From:
Sent: 16 April 2026 00:29
To: DC Admin
Subject: Formal objection - Planning application 2026/90937

Re: Planning Application 2026/90937 – Gomersal St Mary’s CE Primary School

Section 01
Scale 1:100

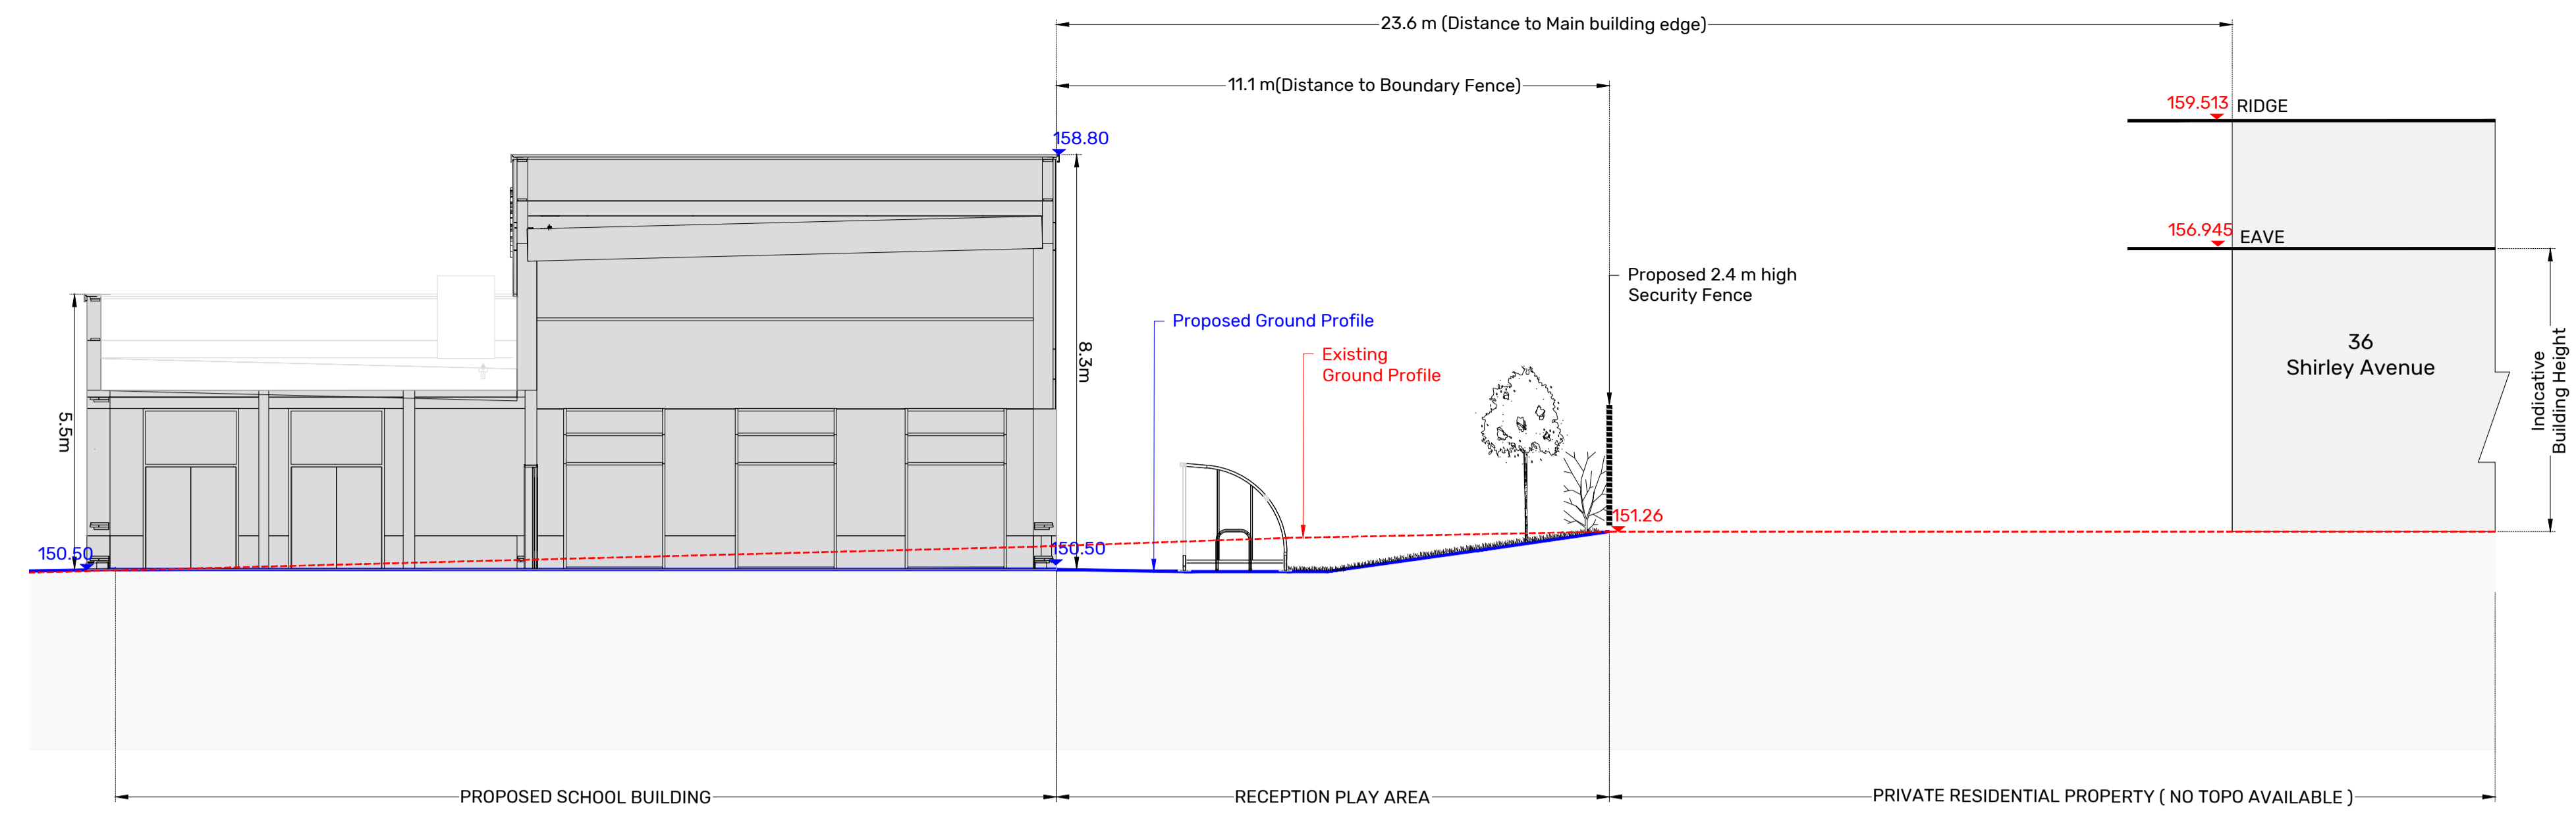
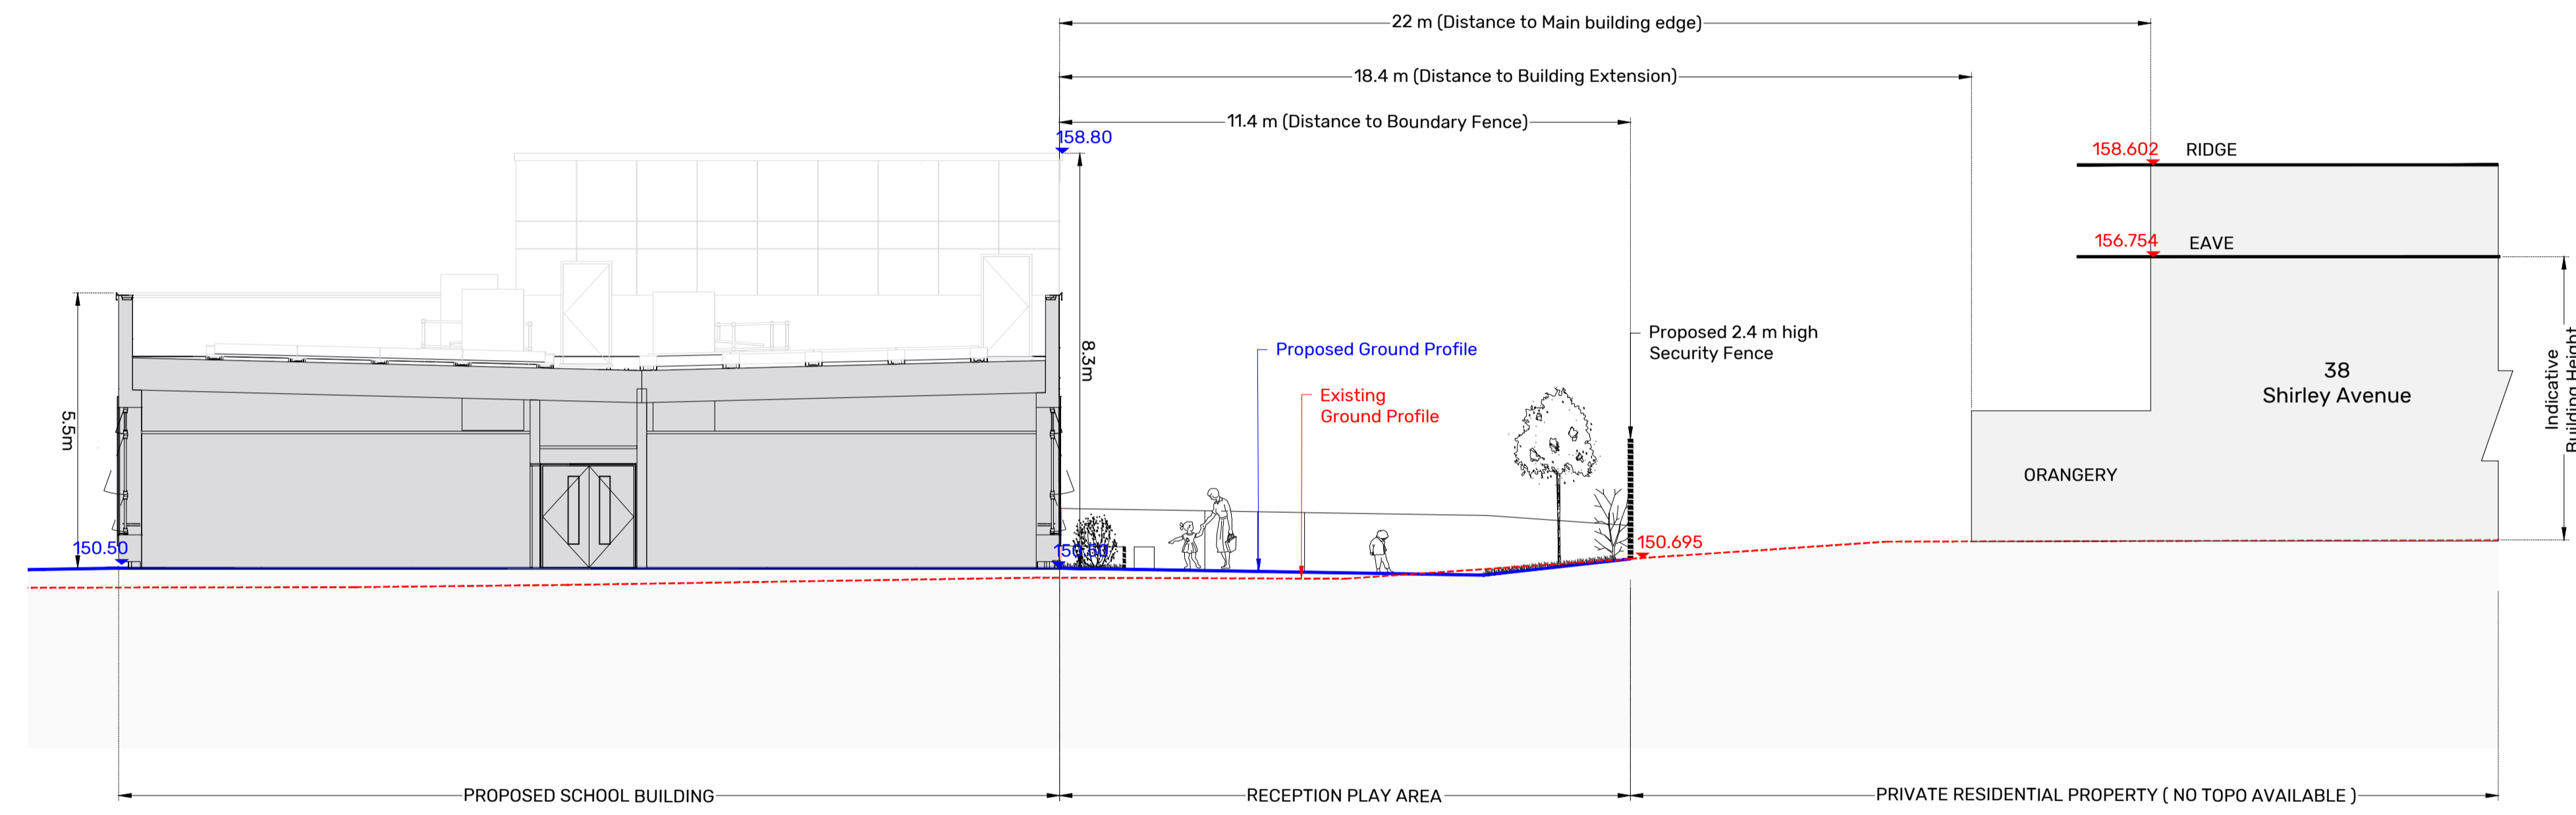
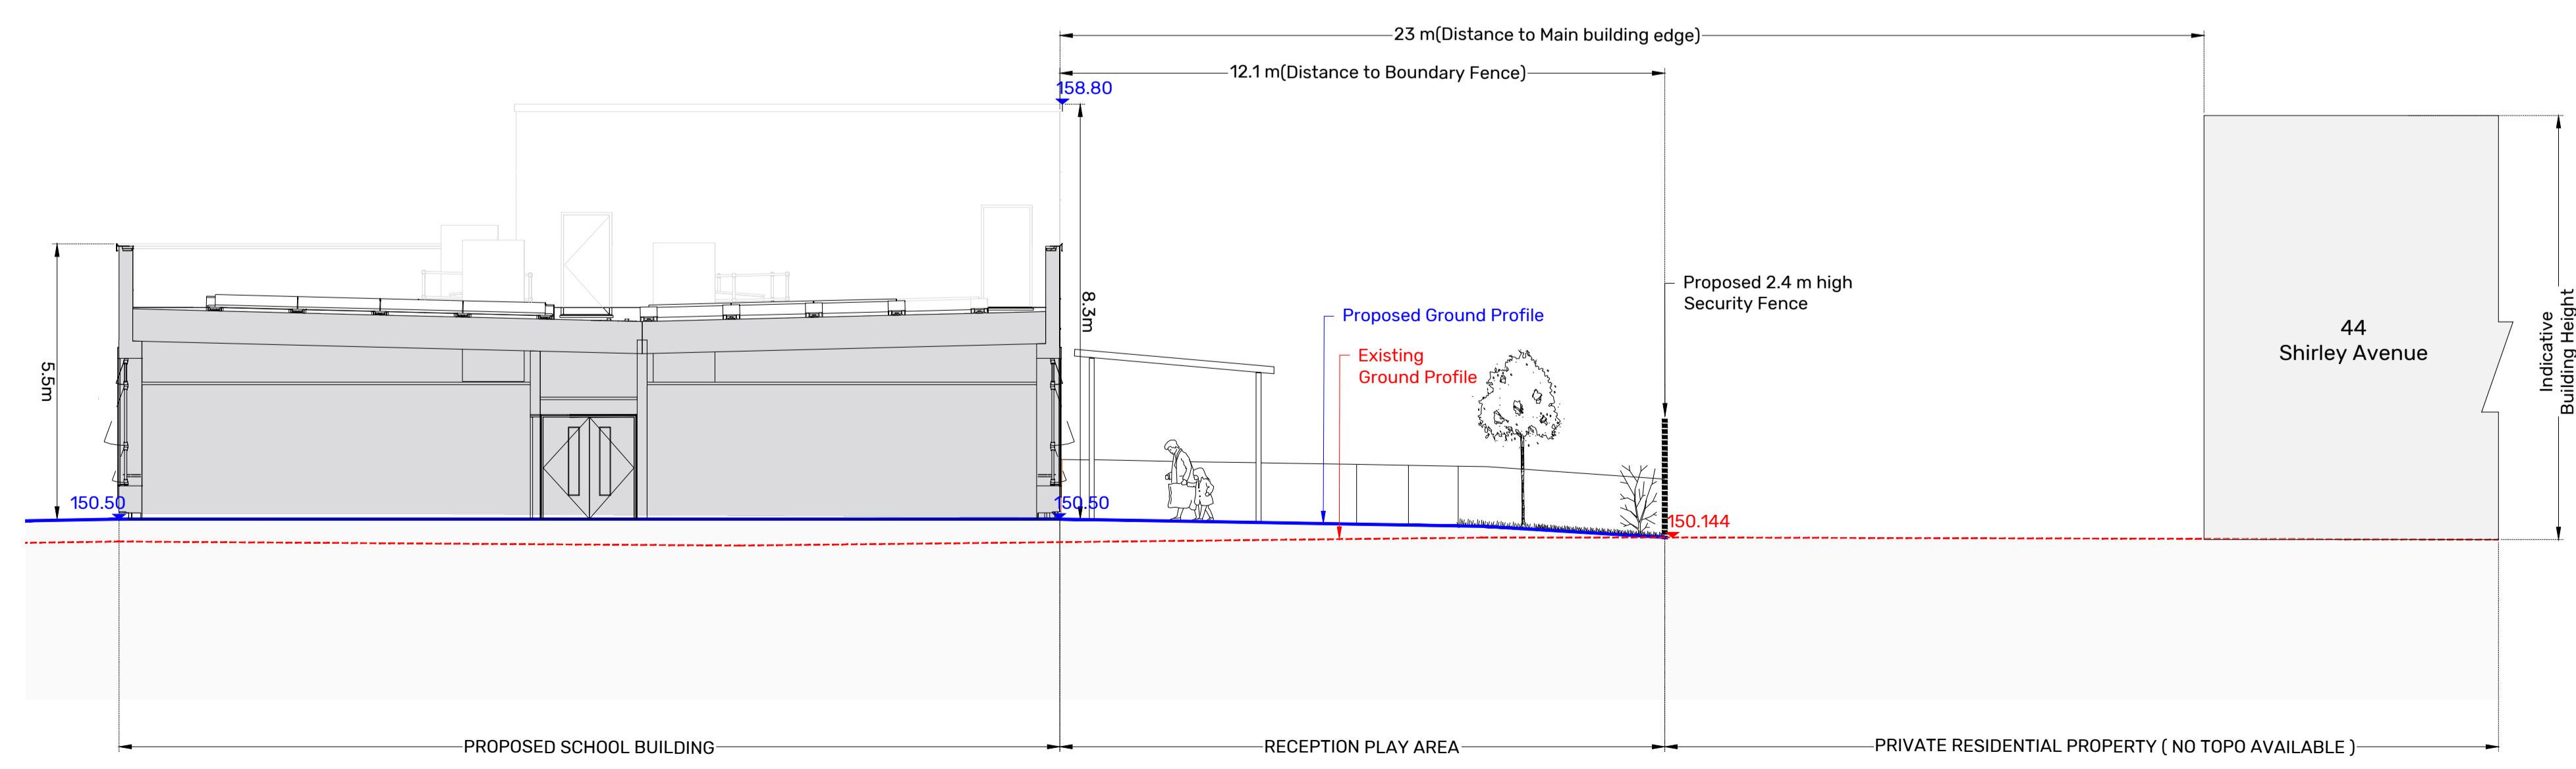
The submitted elevations confirm that the building reaches approximately 8.334 metres in height, which is substantial despite being described as “single storey”. Positioned close to the eastern boundary, this results in a large and continuous built form directly adjacent to residential properties. In my view, this creates an overbearing and visually dominant structure, resulting in a material loss of outlook and an increased sense of enclosure when viewed from neighbouring gardens.
